CITY OF ALBUQUERQUE

January 29, 2020

Re: TI @ 1430 Broadway SE
1430 Broadway Blvd SE
Traffic Circulation Layout
Engineer's/Architect's Stamp 1/24/20 (L14D062)

TCL

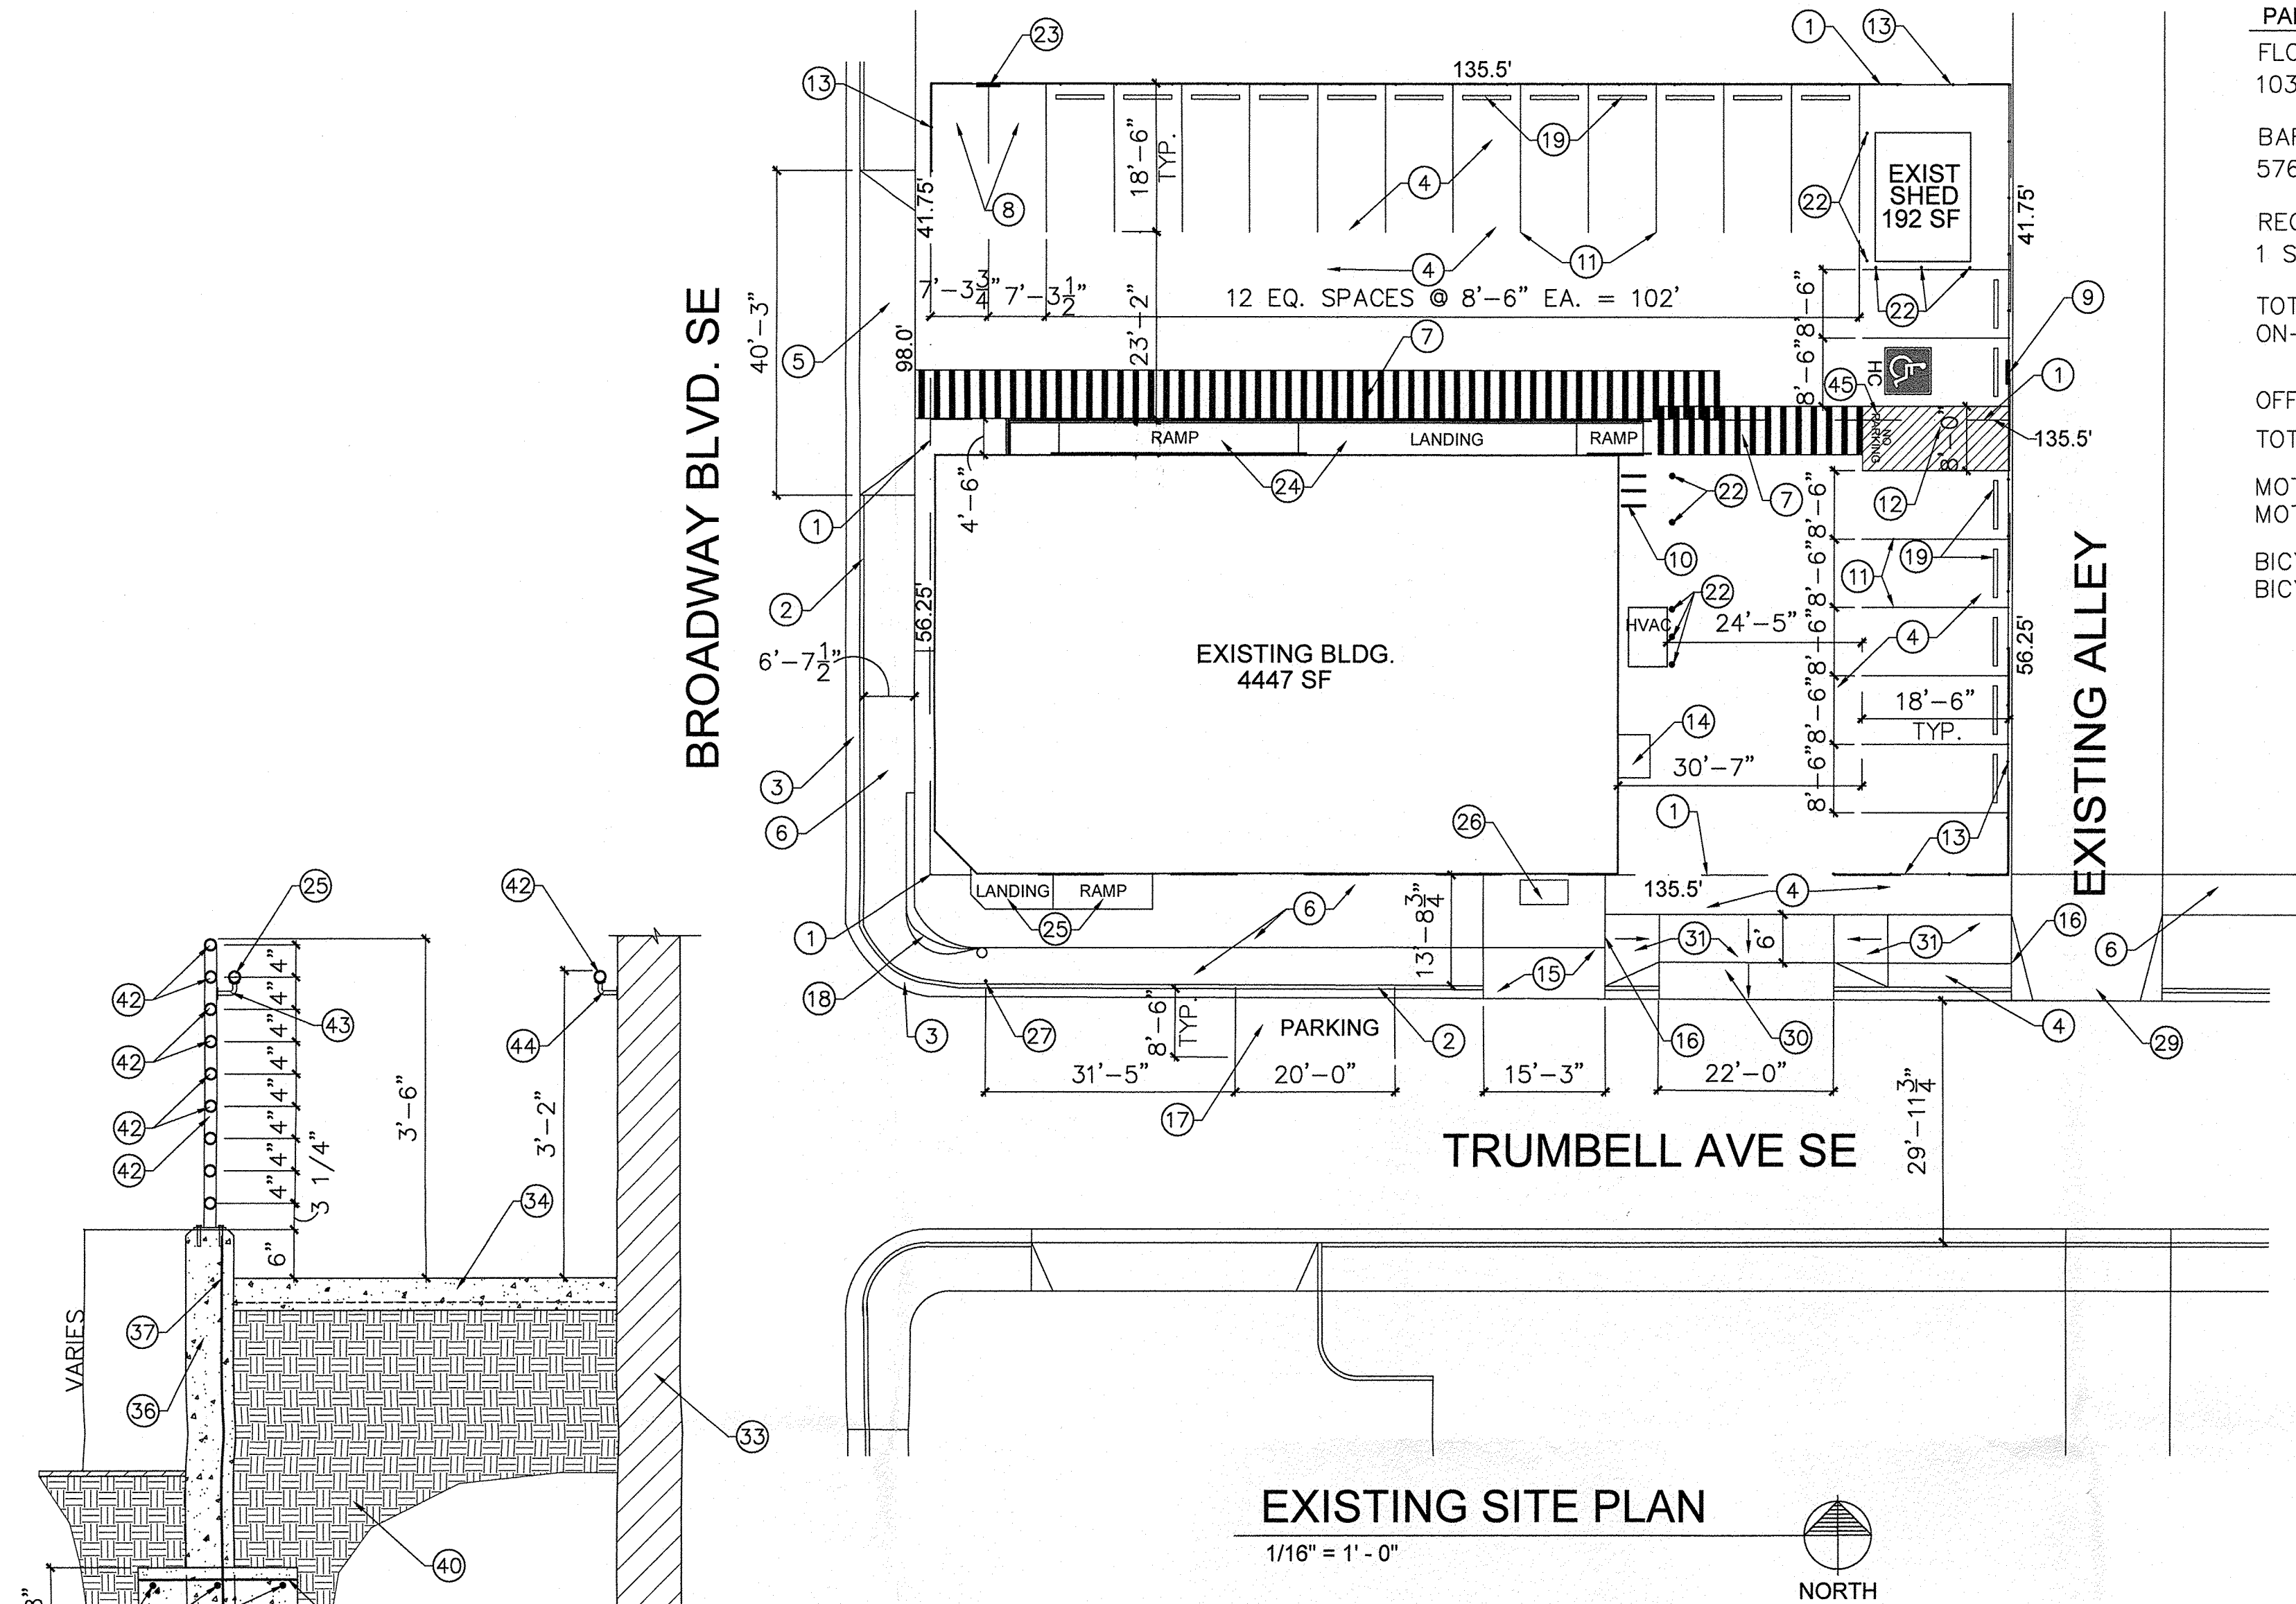
1. Please callout sidewalk width off Broadway.
2. Please callout width of Trumbell Ave SE.
3. Clarify existing property lines and proposed property lines. Property appears to have 2 addresses. (1430 & 1420 Broadway Blvd SE)

4. Parking spaces cannot cross over lot lines.
5. Please add note: The ADA access aisles shall have the words **"NO PARKING"** in capital letters, each of which shall be at least one foot high and at least two inches wide, placed at the rear of the parking space so as to be close to where an adjacent vehicle's rear tire would be placed. (66-1-4.1.B NMSA 1978)

6. Please add note for Pipe Bollard color, Yellow.
7. Service vehicle and/or refuse vehicle maneuvering must be contained on-site; provide a copy of refuse approval.

8. Please specify the City Standard Drawing Number when applicable. Add side walk standard drawing #.
9. Please include a copy of your shared access agreement with the adjacent property owner.

12. Add a note stating "All broken or cracked sidewalk must be replaced with sidewalk and curb & gutter." A build note must be provided referring to the appropriate City Standard drawing.

13. Please add ramp detail to TCL Plan. Include notes: Not to exceed Max running slope of 8.0% and Max Cross slope of 2.0%
14. Please add a curb protection. See plan for location. Bike Rack and unidentified unit protected by Bollards.
15. Please remove off street parking stall between drive access and alley.
16. Please include one copy of the traffic circulation layout at the next submittal.
